On 1st September, Barnham & Eastergate Parish Council Full Council resolved to submit a no objection response, subject to the following areas of concern being addressed.

Application No: BN/84/20/PL
Registered: 29th July 2020
Site Address: Land at Angels Nursery Yapton Road Barnham PO22 0AY
Grid Reference: 496255 104047
Description of Works: Application for variation of conditions imposed on planning reference BN/43/16/PL relating to Conditions 2 (Approved Plans), 8 (Access/Maintenance of Watercourse or Culvert) and 18 (Access and Associated Off-Site Highway Works).

ANGEL'S NURSERY, BARNHAM - 2 BED APARTMENTS GROUND FLOOR PLAN AH

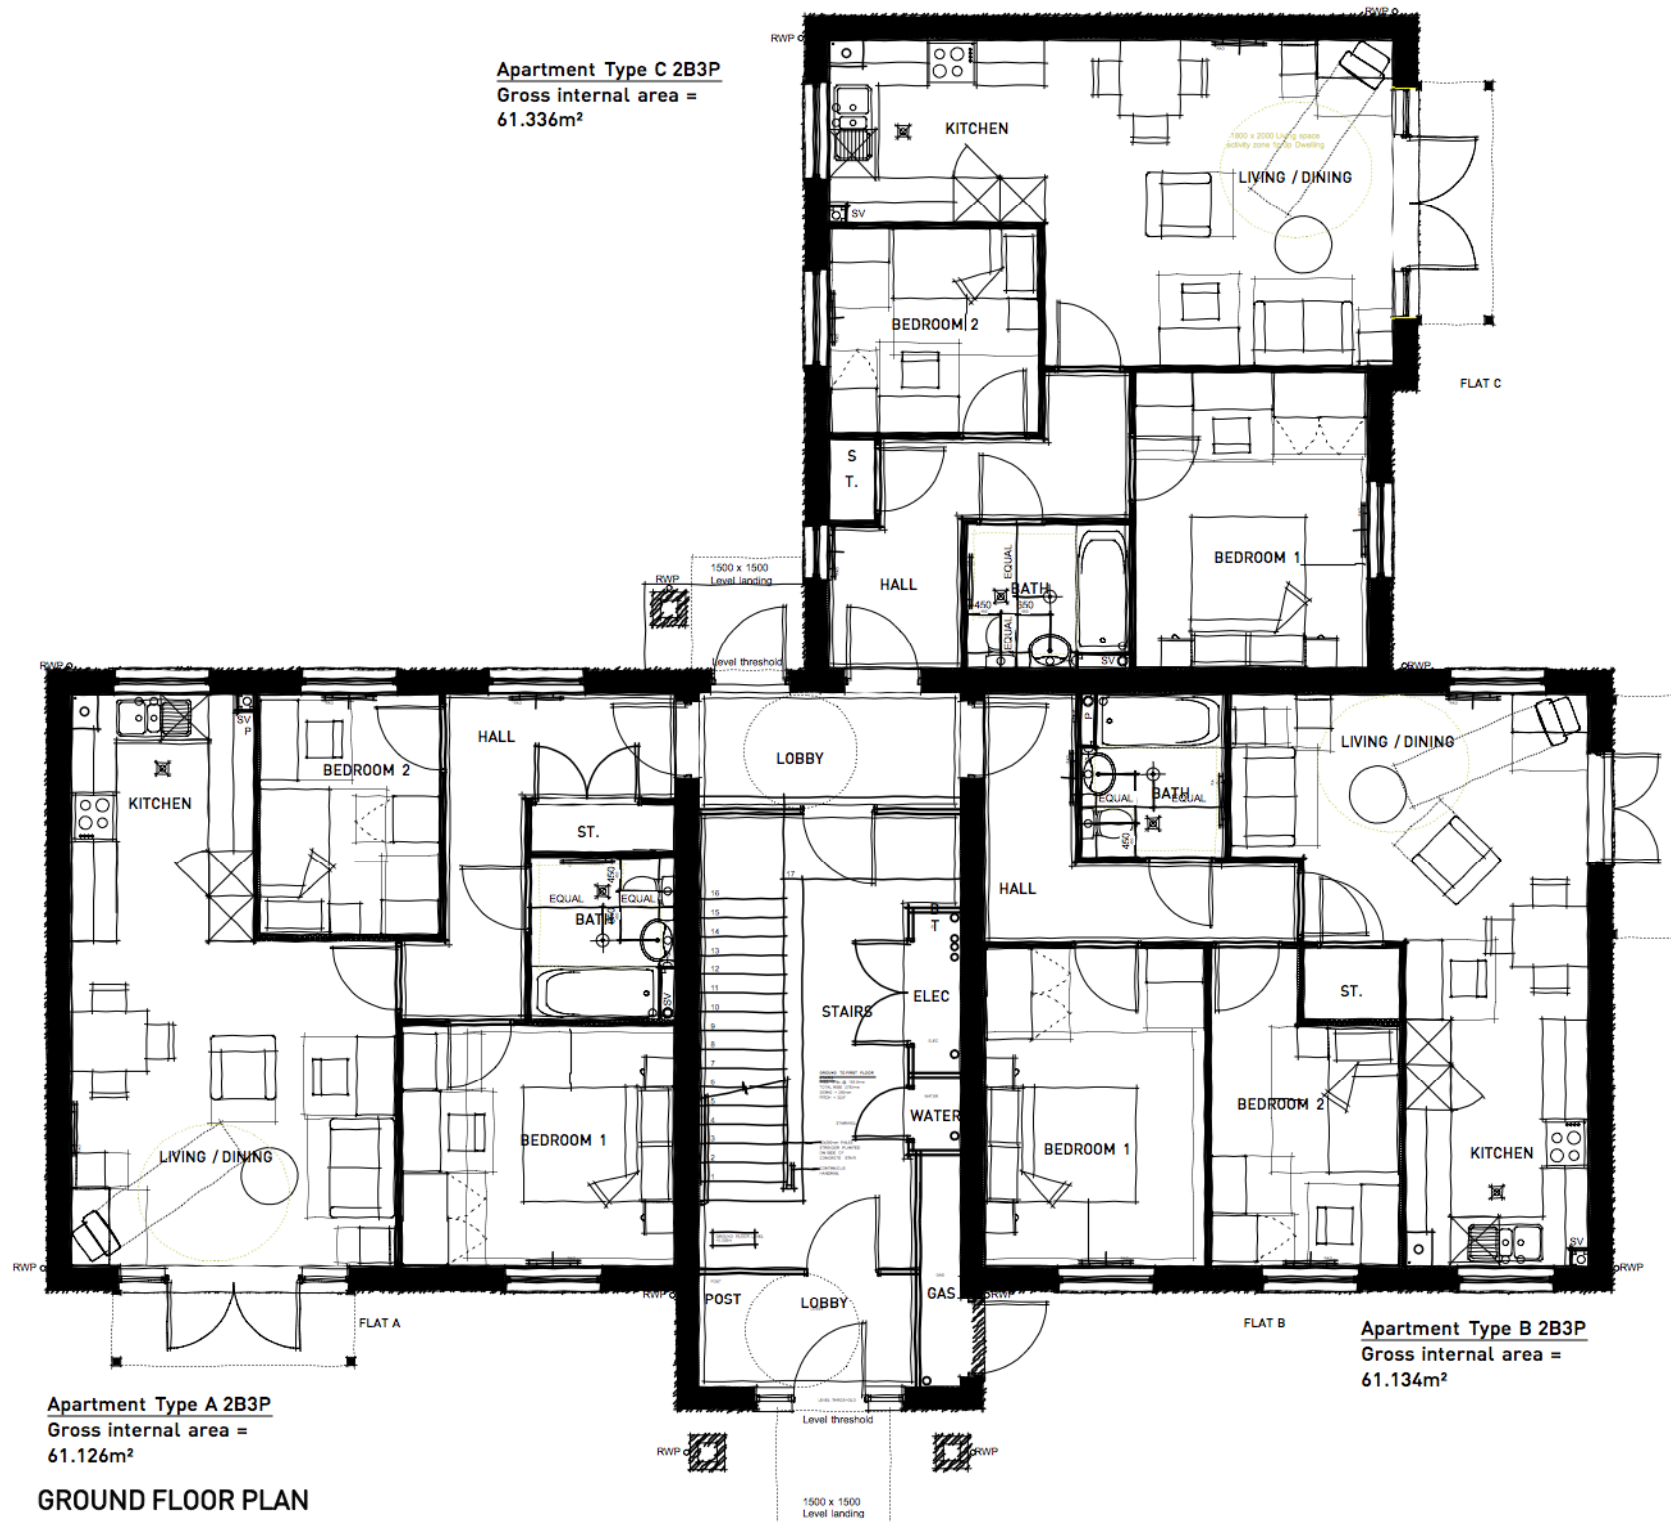
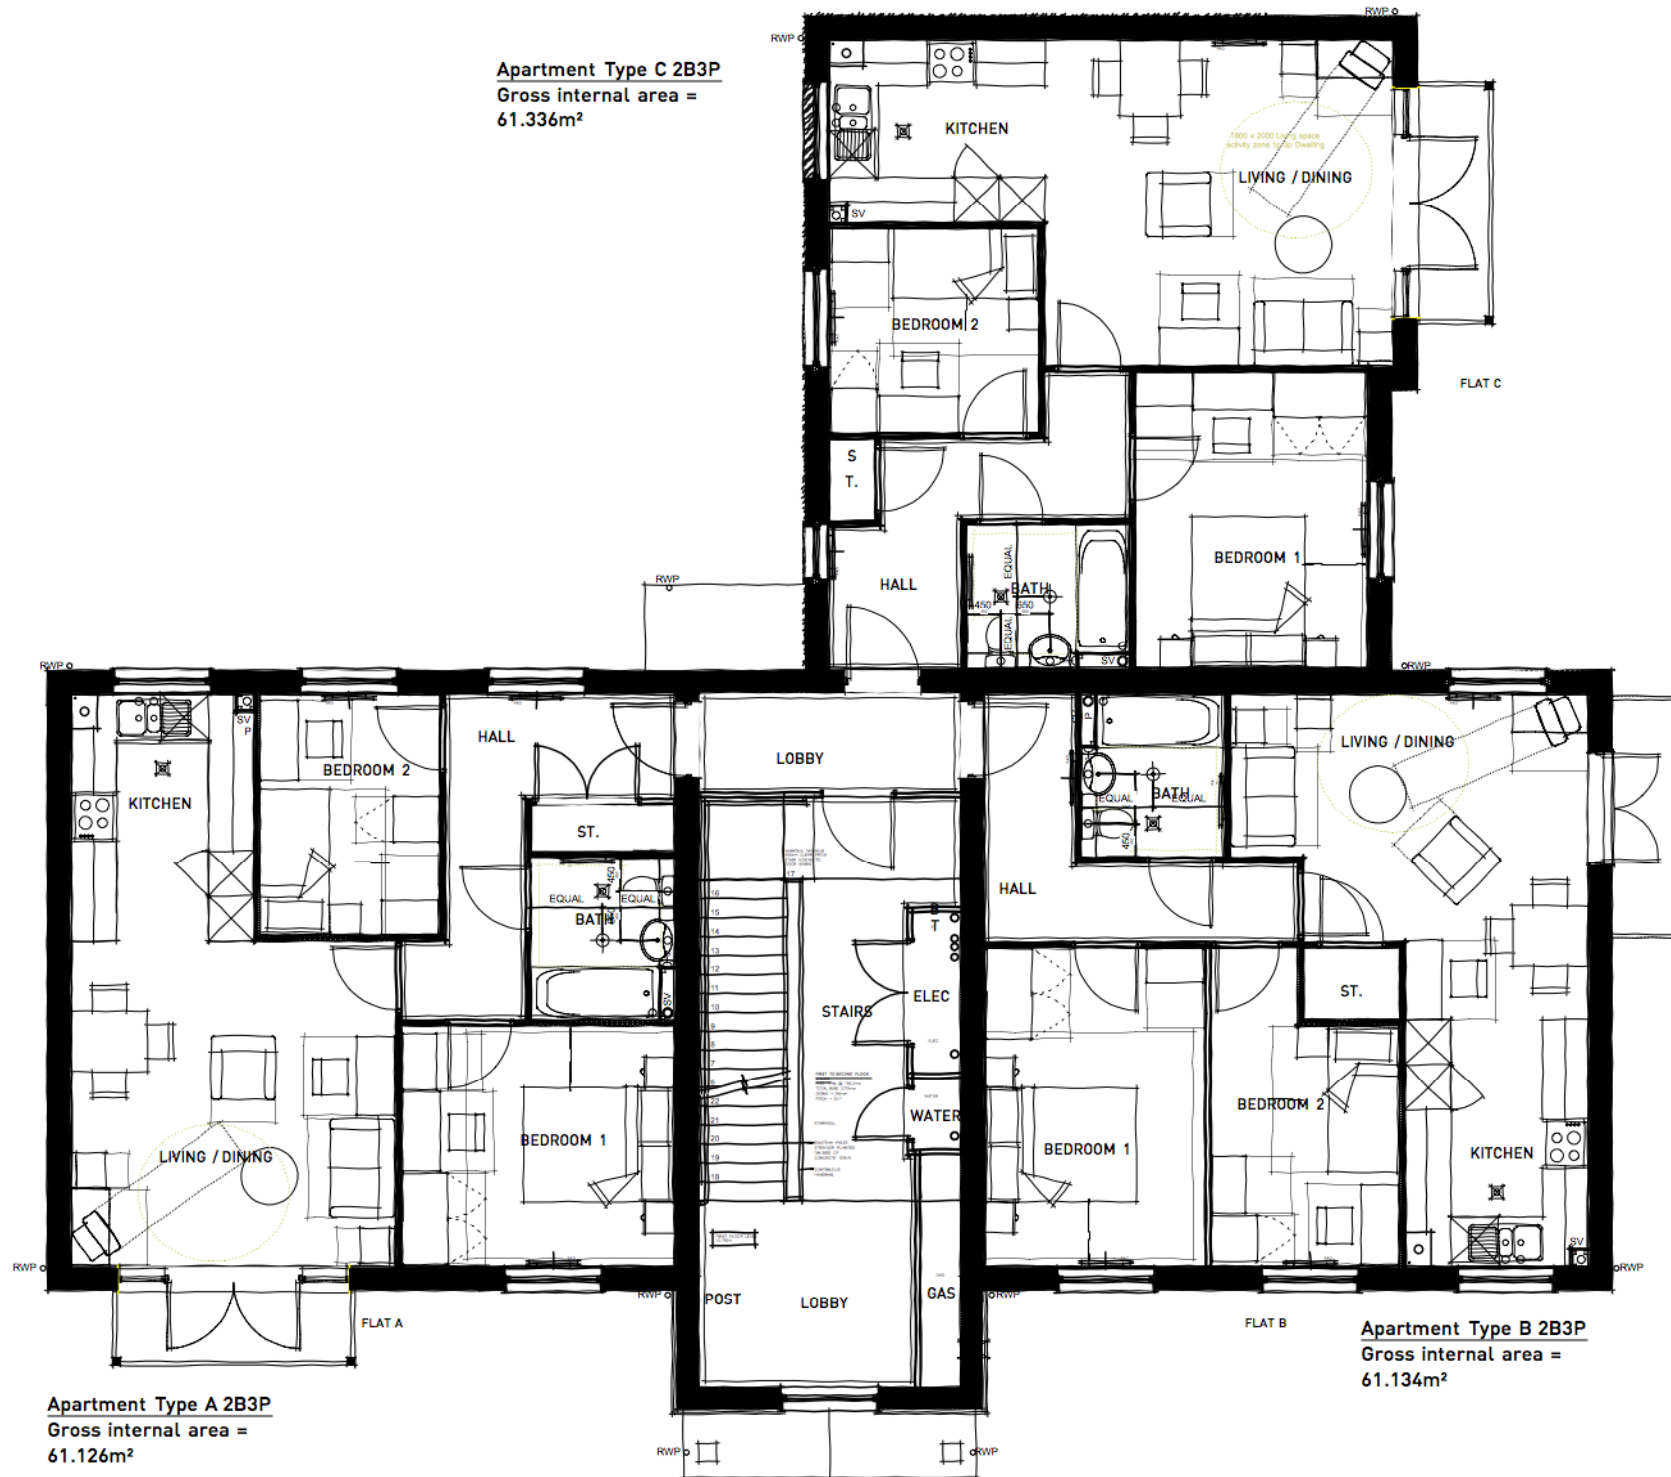
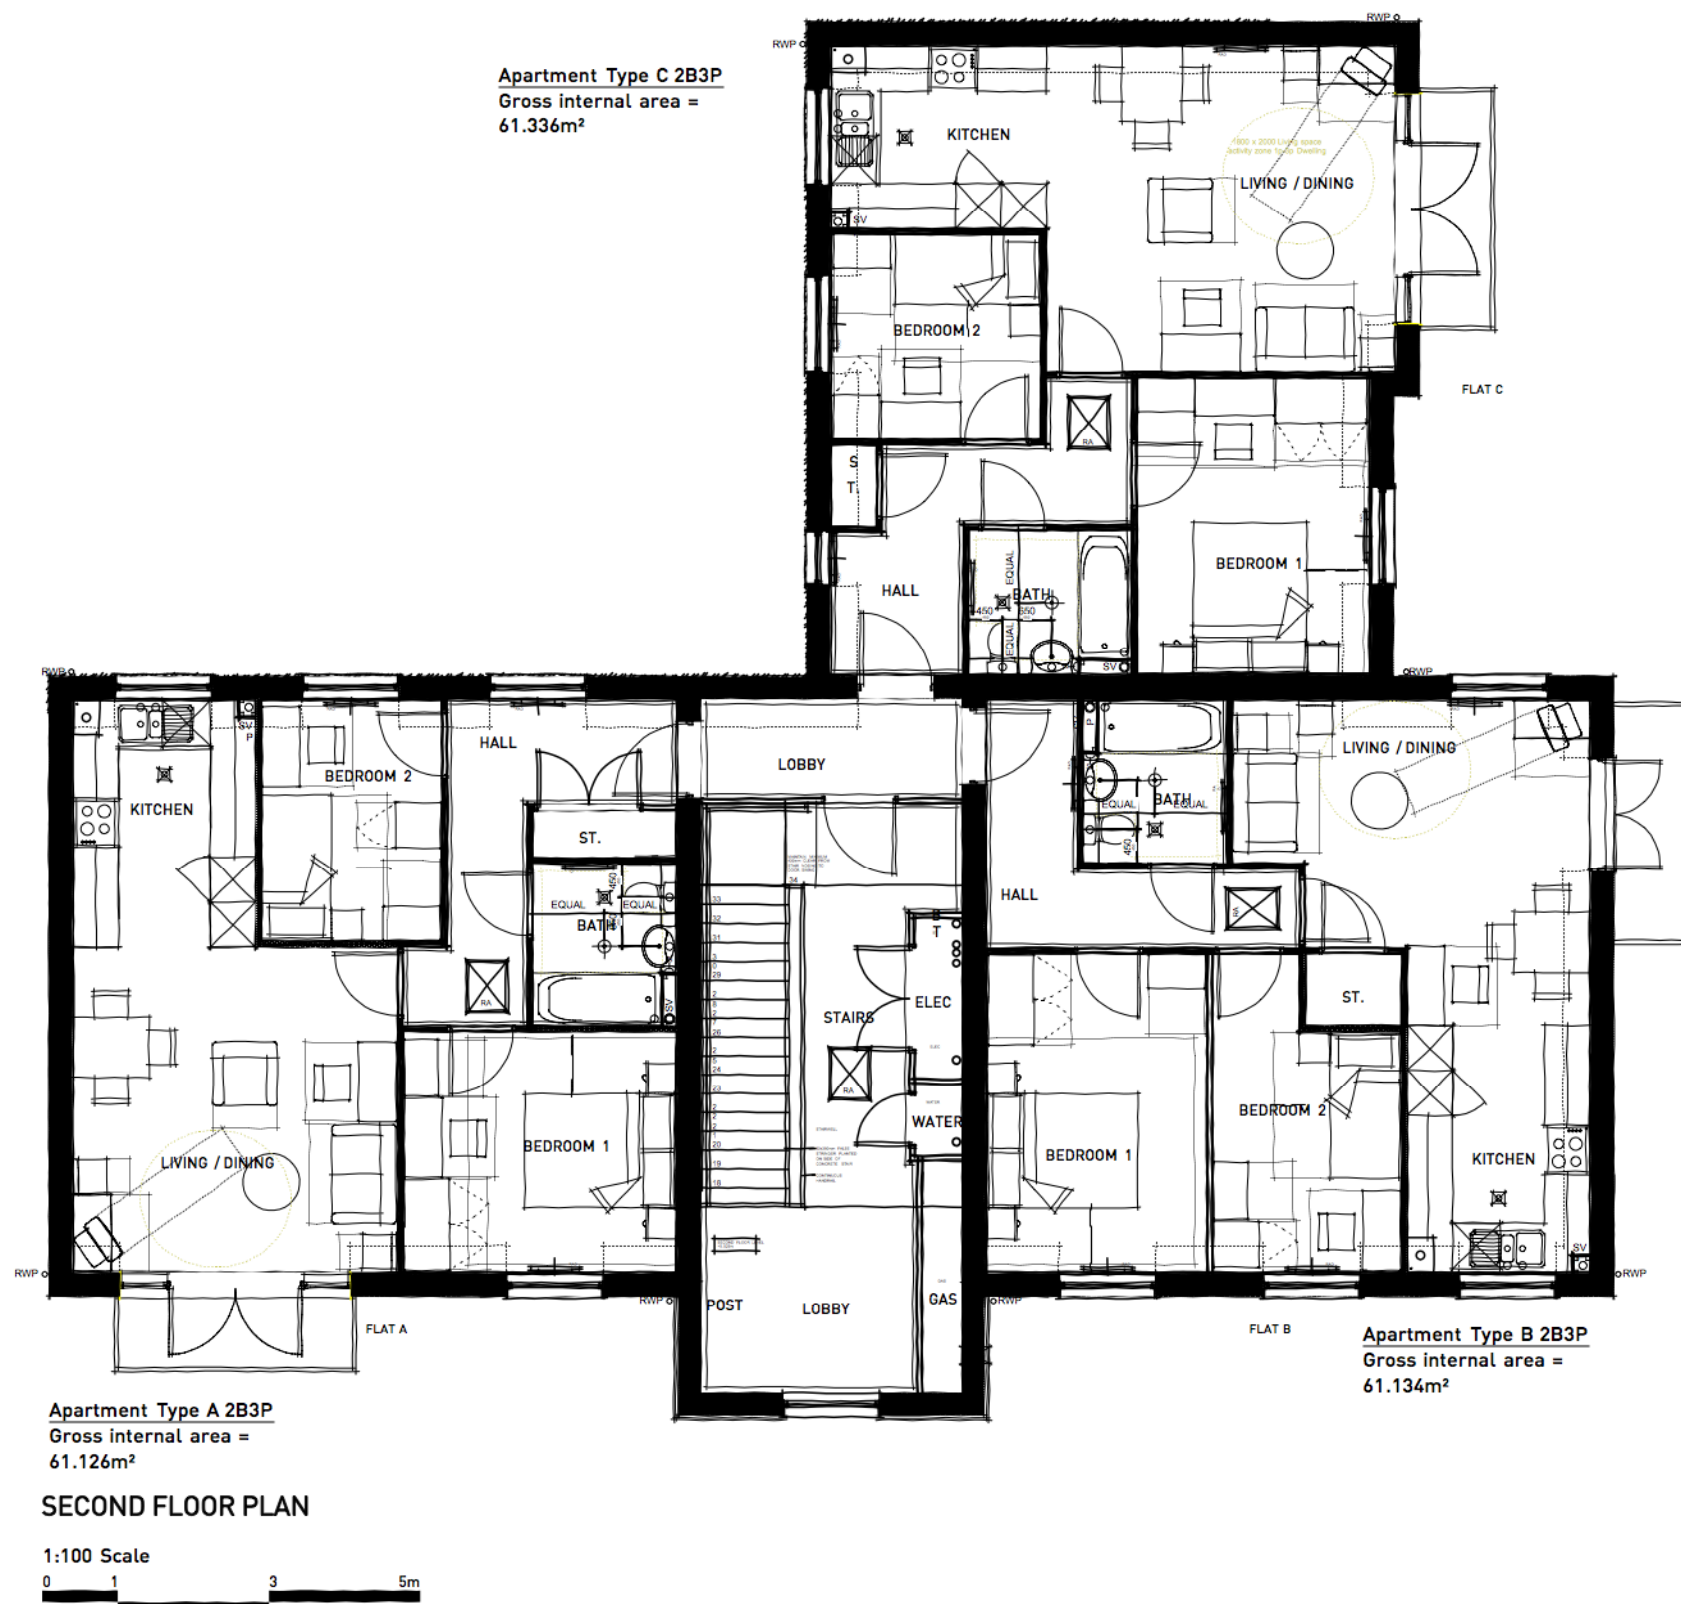
- Reconsider the design of the current three storey building in southeast corner to a 2.5 storey design (as this contravenes a policy in the emerging Neighbourhood Plan);
